Blacktown
City Council

Your ref: SSD 10477
File no MC-20-00007

SSD 10477 – Request for SEARs – Stage 3 Facilities Sydney Business Park, Marsden Park

Blacktown City Council submission to SSD 10477 – Stage 3 Facilities Sydney Business Park, Marsden Park

Title: ROUNDABOUT VEHICLE TURNING PATH PLAN SHEET 01 OF 03				
Project No.	Set No.	Milestone	Plan	Revision
20-0127	02	DA	600	A

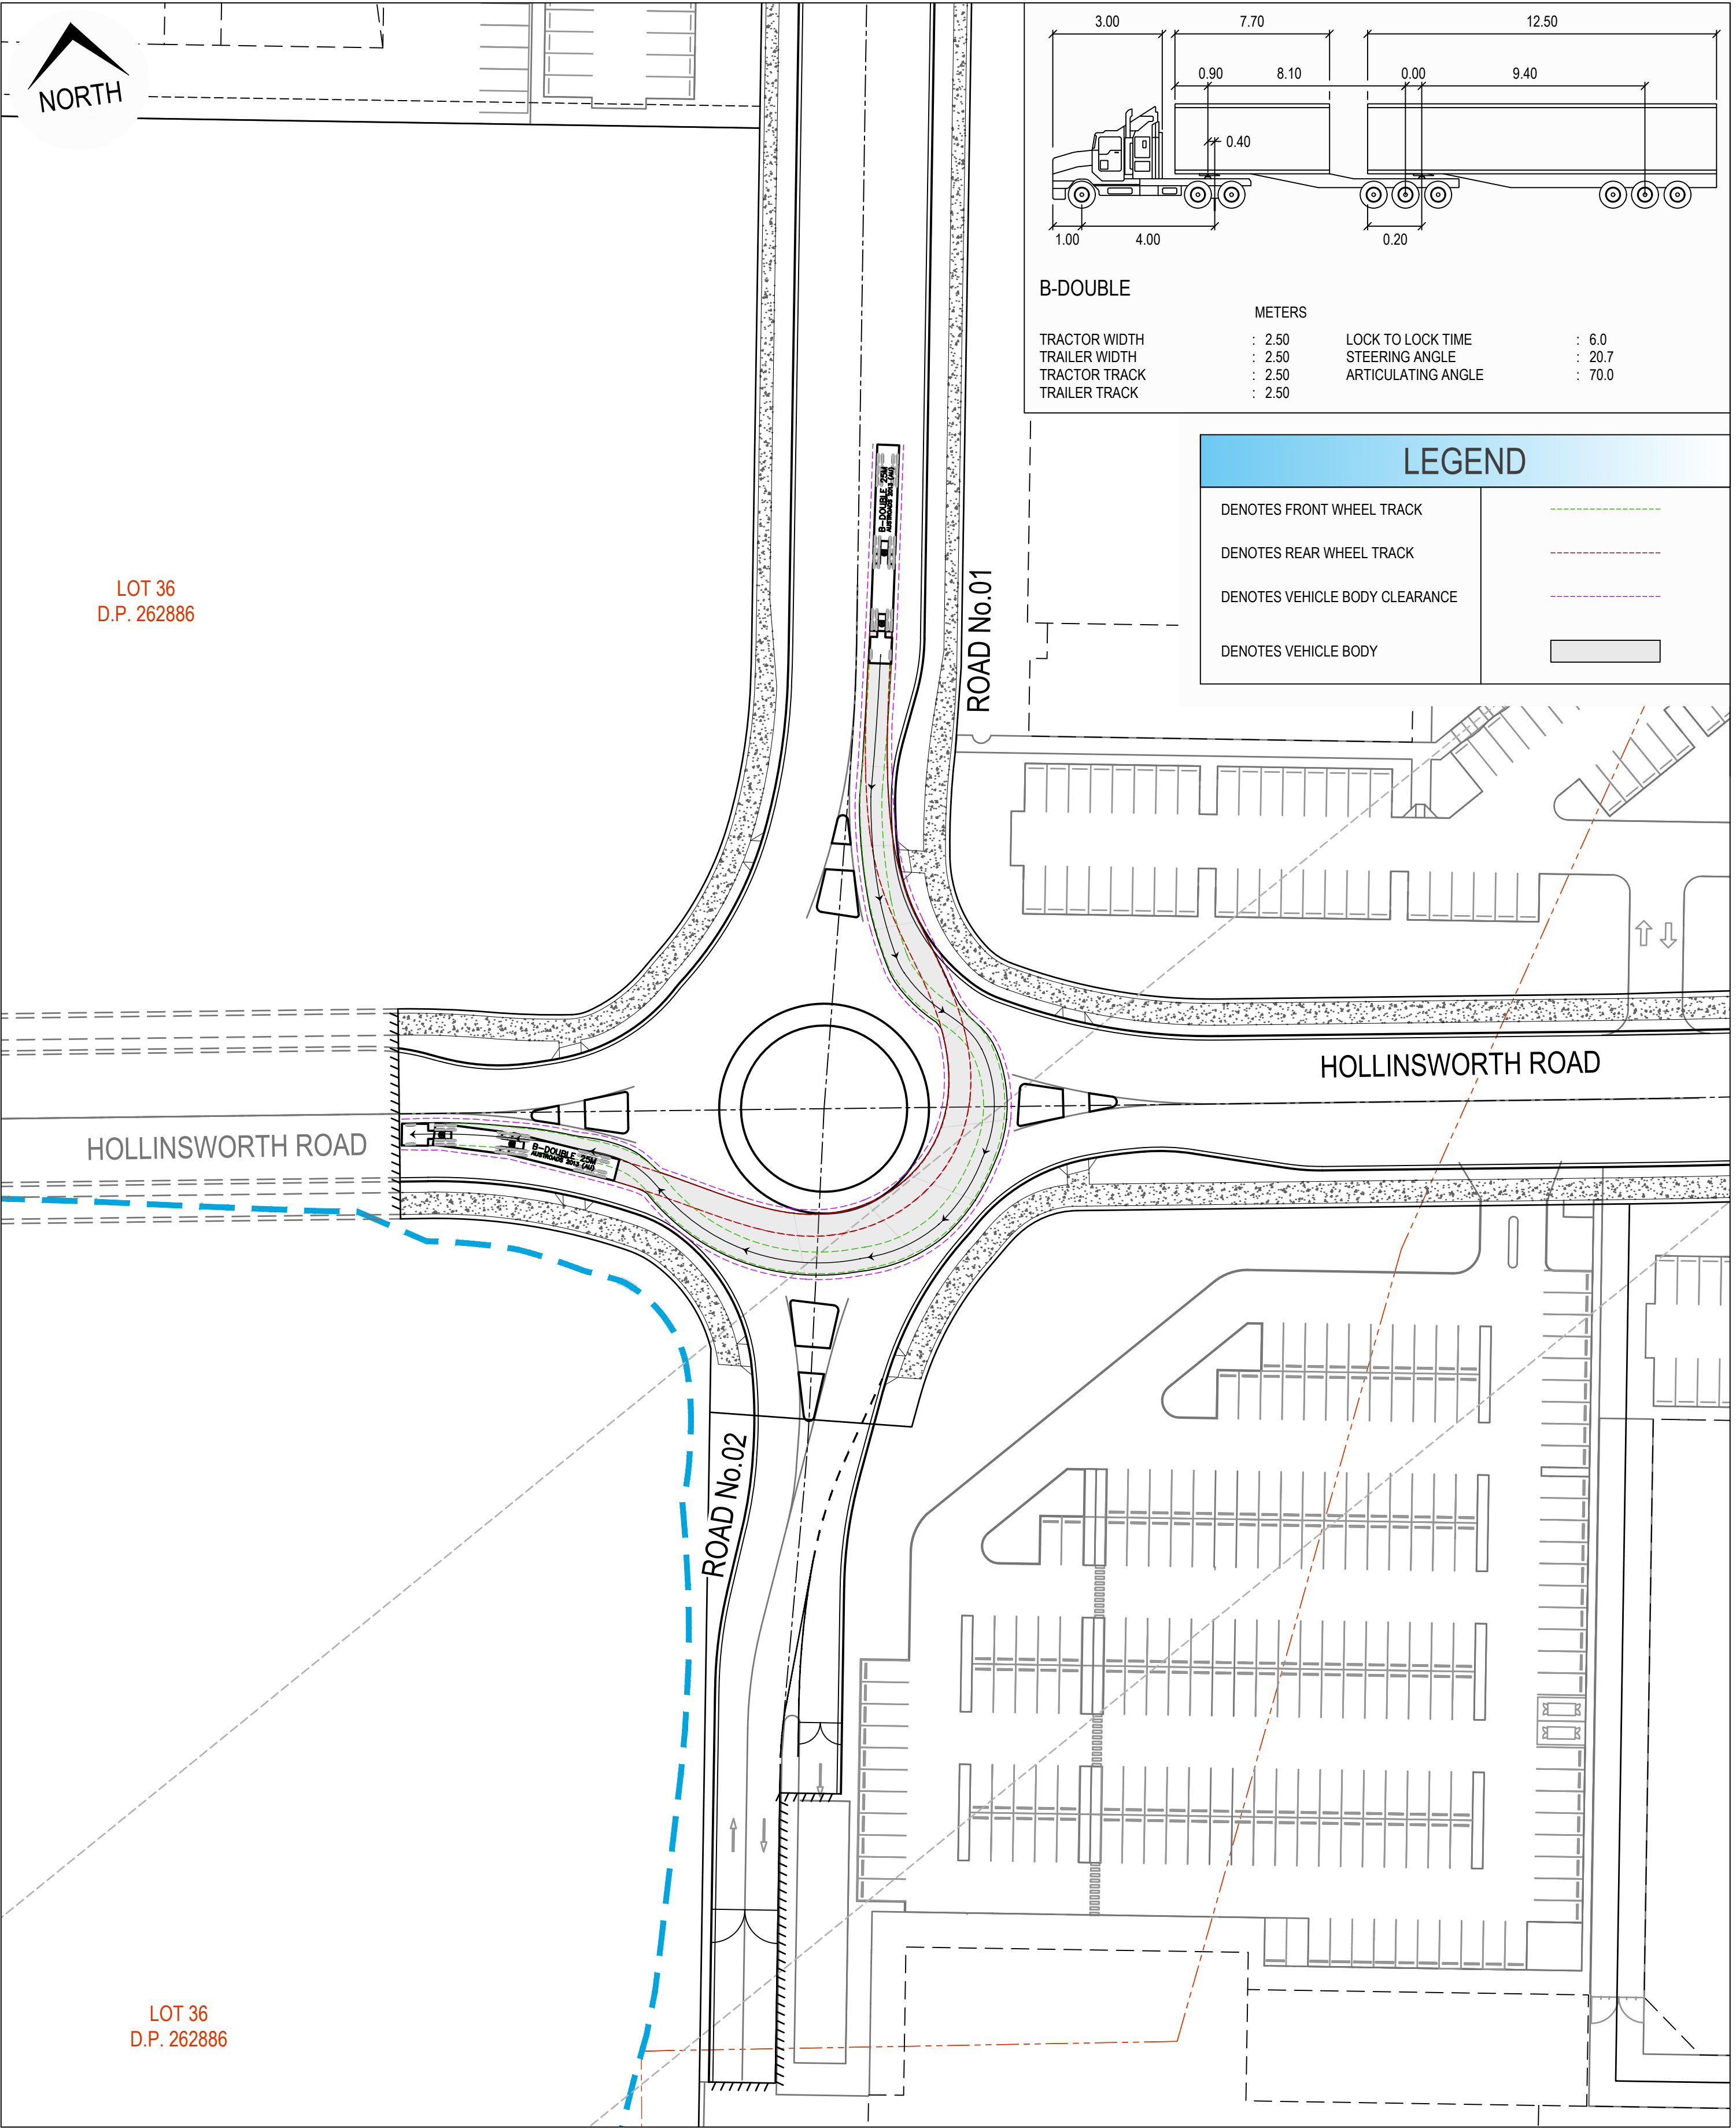
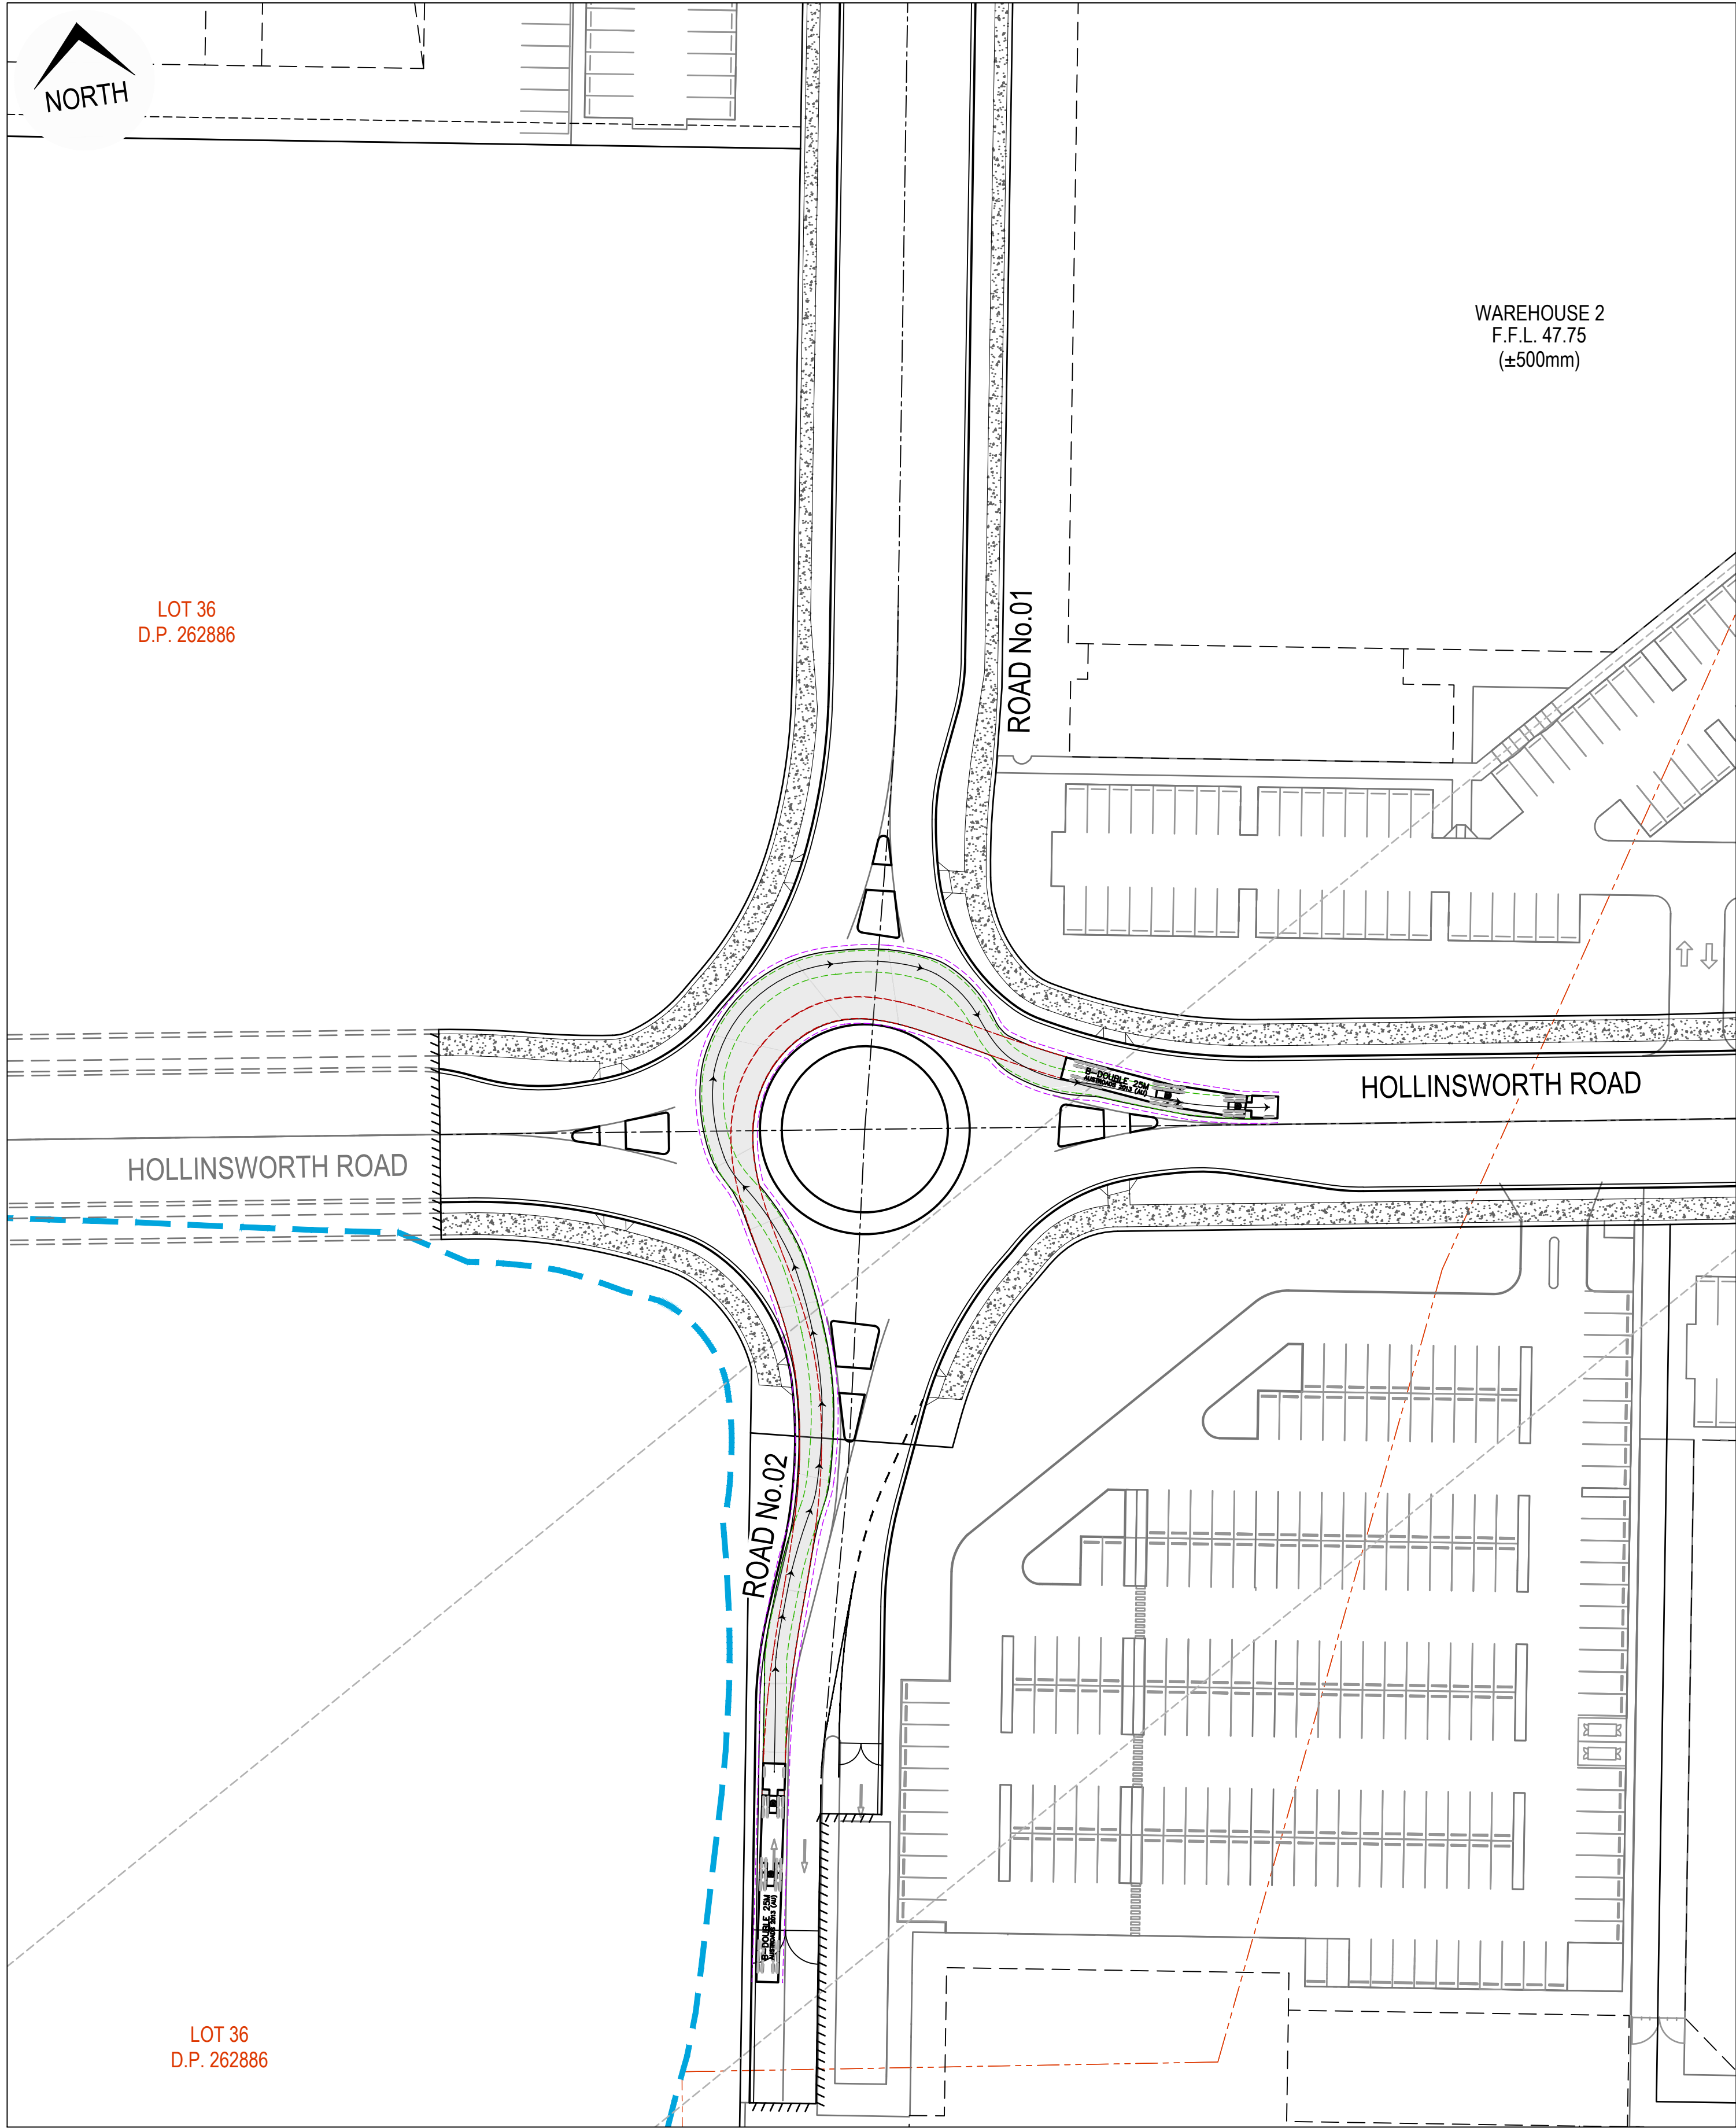
- g. The heavy vehicle driveway proposed to service Warehouse 4 is shown within the roundabout kerb line. In order for this to be considered by Council, a fourth southern leg of the roundabout must be proposed as a public road, with a transition to private driveway after a short distance. This is to ensure the vehicle movements within the roundabout are kept uniform and consistent to ensure road safety is prioritised for all directions of traffic.

- h. The design vehicle for the roundabout is a B-triple, for which turning / swept paths will need to be provided on a copy of the engineering plans, to be assessed with the submission.
